City of Albuquerque
Stormwater, Erosion, and Sediment Control
Construction Site Inspection Report

ESC File #:	M14E038	Project Name:	Love's BP
ABQ-PLAN #:	SWQ-2025-00042	Project Address:	3200 Broadway Blvd SE
NPDES ID #:	NMR1006RE / 6AW	Inspection Type:	Follow-up
3/16/2026	Owner		Contractor
Operator:	ABQ Terminal LLC	Harris United	
Contact Name:	Spencer Haines	John Arenz	
Contact e-mail:	michelle.wright@loves.com	john@harrisunited.com	
Contact Phone:	405-847-5297	918-500-6678

COA Inspector:	Chancellor English	Date of Inspection:	3/11/2026	Time of Inspection:	3-5pm
NPDES Posting?	Yes	SWPPP?	Yes	Notice of Intent?	Yes
Self-Inspection Reports?	Yes	Date of last report: 3/3/2026			
Weather during inspection:	Clear	Estimated date of last storm 0.25" or greater: 1/25/2026 Snow			
Temperature: ~	70	Construction Phase: Work Order, landscaping			
Discharge off-site?	No	ROW: N/A

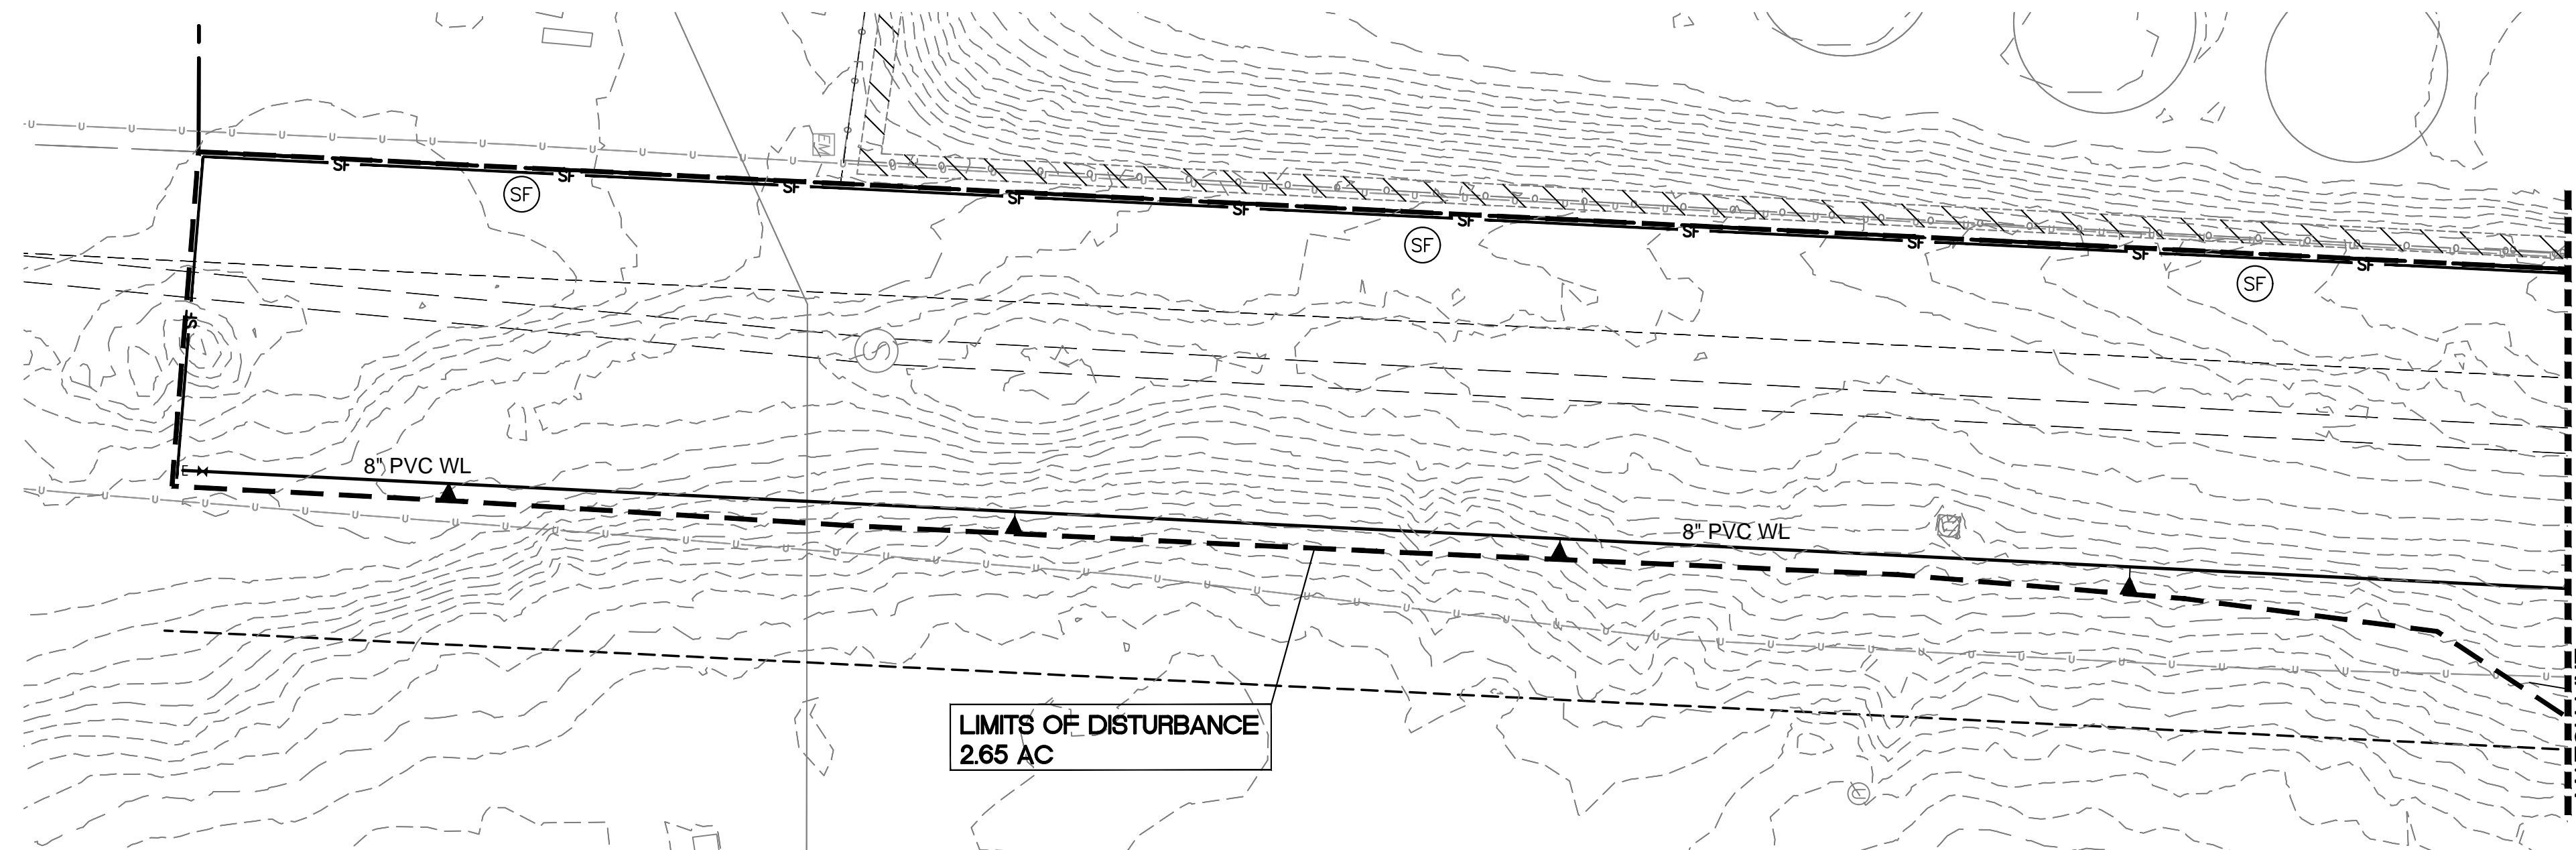
Item #	Violation Category	Deficiency/Corrective Action
3	SWPPP	The on-site SWPPP Map was not the ESC Plan approved by the City (Engineer's Stamp 6/11/2025), and there are no plans with accurate post-construction contours for the Arno St addition in violation of CGP Part 7.2.4. Required mitigation: Resubmit an ESC Plan to the City SWQ showing existing and proposed grades and limits of disturbance based on field measurements per CGP Part 7.2.4.f. Ensure to differentiate between areas of slope stabilization (City Spec 1013) and native seed and aggregate mulch (City Spec 1012). Please include the amended and approved ESC Plan in the modified SWPPP.
4	BMPs	Silt fences have been removed downgradient of land still disturbed along the Arno St addition to prevent sediment run-on from the east property and sediment discharge to the west into the county pond in violation of CGP Parts 2.2.3 and 2.1.4. Required mitigation: Install sediment controls along any perimeter areas of the site that are downslope from any exposed soil or other disturbed areas per CGP Part 2.2.3. Ensure all stormwater controls are maintained and remain in effective operating condition during CGP coverage per CGP Part 2.1.4.

The pond and the surrounding area, along with the disturbed areas along the Arno St addition require seeding and stabilization per City Specifications 1012 and 1013.
